Our Ref: TS/DAN/E4736/17675

26th May 2020

Arun District Council
Planning Department
C/O
Dandara Southern

FONTWELL –RESPONSE TO DRAINAGE COMMENTS

Drawing No. **FON-130-09-D**

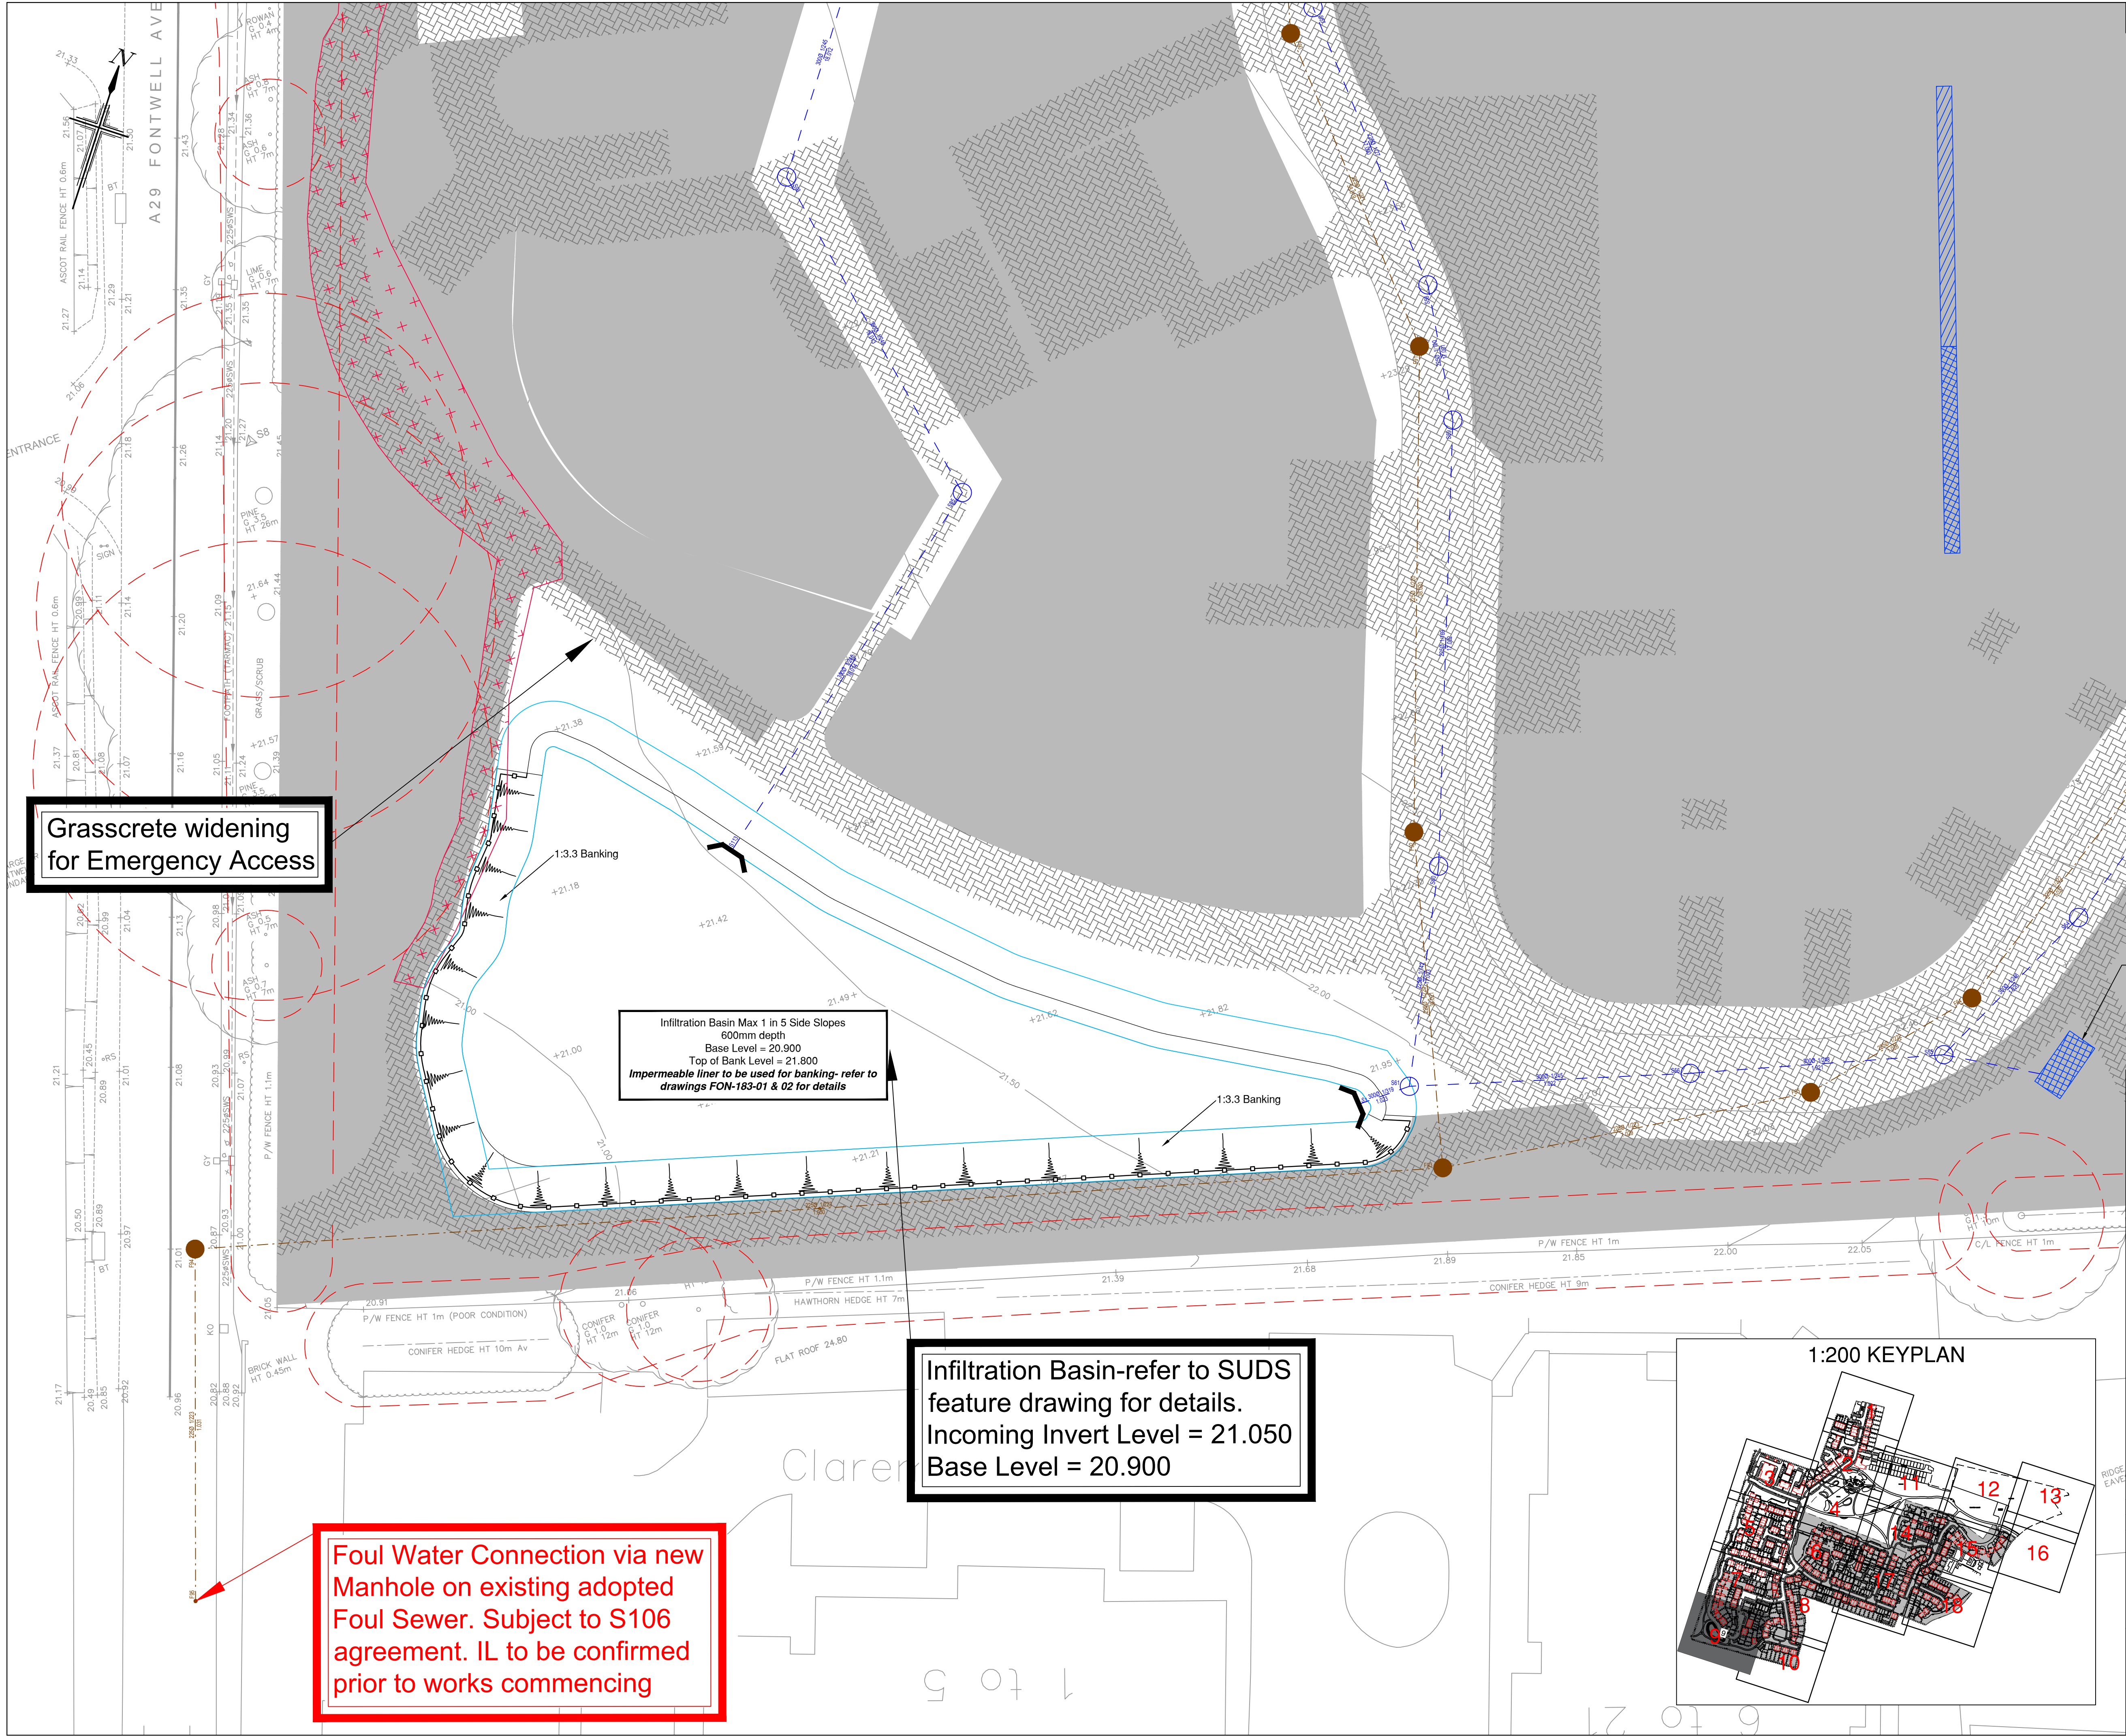
9. *Indicated all pipe inverts, diameters, gradients, soakaway base and inlet levels-* This information is provided on the Domestic Drainage Layout drawings FON-130-01 to 10;
